M25 junction 28 improvement scheme

10.17 Report on Proposed Scheme Change 8

M25 junction 28 scheme Development Consent Order 202[x]

2. Change 8 – Grove Farm egress – revisions to Work No. 15

**Fig 3.1 - HE Indicative alignment of amended Grove Farm egress (Change 8)**

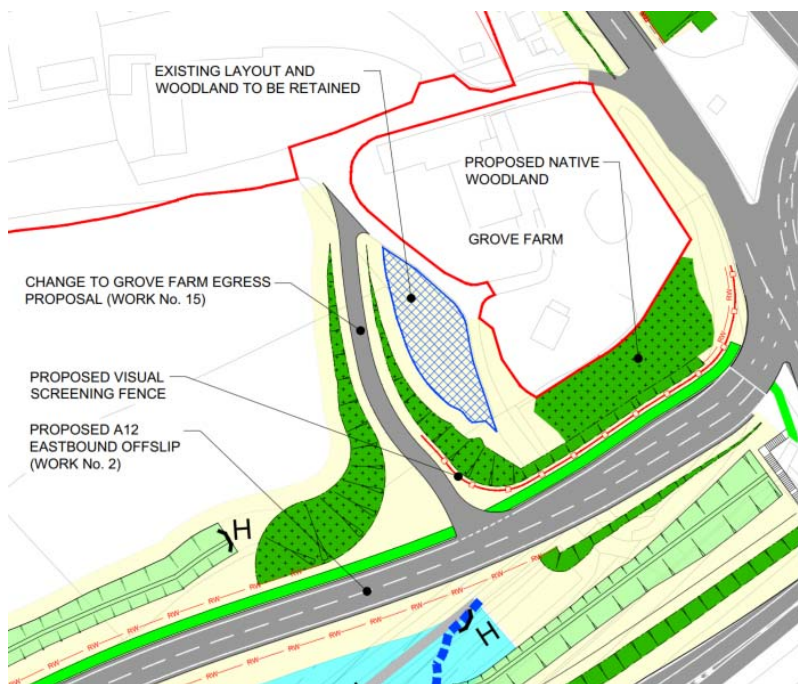
- 2.1.1 In the submitted Application for the Scheme, Highways England proposed to alter the existing egress from Grove Farm (Work No. 15) to tie into the realigned A12 eastbound off-slip (Work No. 2) to allow the Farm to continue to use it once the Scheme was in operation.

- 2.1.2 Following representations received from the owners of Grove Farm regarding their concerns about the proximity of the proposed Grove Farm egress (Work No. 15) to the farmhouse due to the realignment of A12 eastbound off-slip road (Work No. 2), further design development has been undertaken to address these concerns. Change 8 is to revise the alignment and re-position the proposed Grove Farm egress (Work No. 15) approximately 25 metres further westwards. Proposed Change 8 would result in an extension in the length of this work from approximately 50 metres, to approximately 87 metres.

- 2.1.3 Change 8 also includes the relocation of the associated drainage works on both sides of the egress and boundary fencing which will run alongside the west side of the egress.

- 2.1.4 Change 8 would alter the landscape mitigation planting currently proposed in the submitted Application. It will require additional loss of trees within The Grove woodland to the west side of the egress but it will enable the retention of some parts of the woodland located to the east side of the egress which will provide visual screening for the farmhouse. Change 8 will include additional tree planting on both sides of the realigned egress and replacement woodland planting along the west side of the loop road (Work No. 6). A visual screen is proposed which will run parallel to the A12 off-slip and to the eastern side of the egress to provide additional visual screening to the residents at Grove farm.

- 2.1.5 The Limits of Deviation for the highway works would be revised to reflect the re-positioning of the egress (Work No. 15).
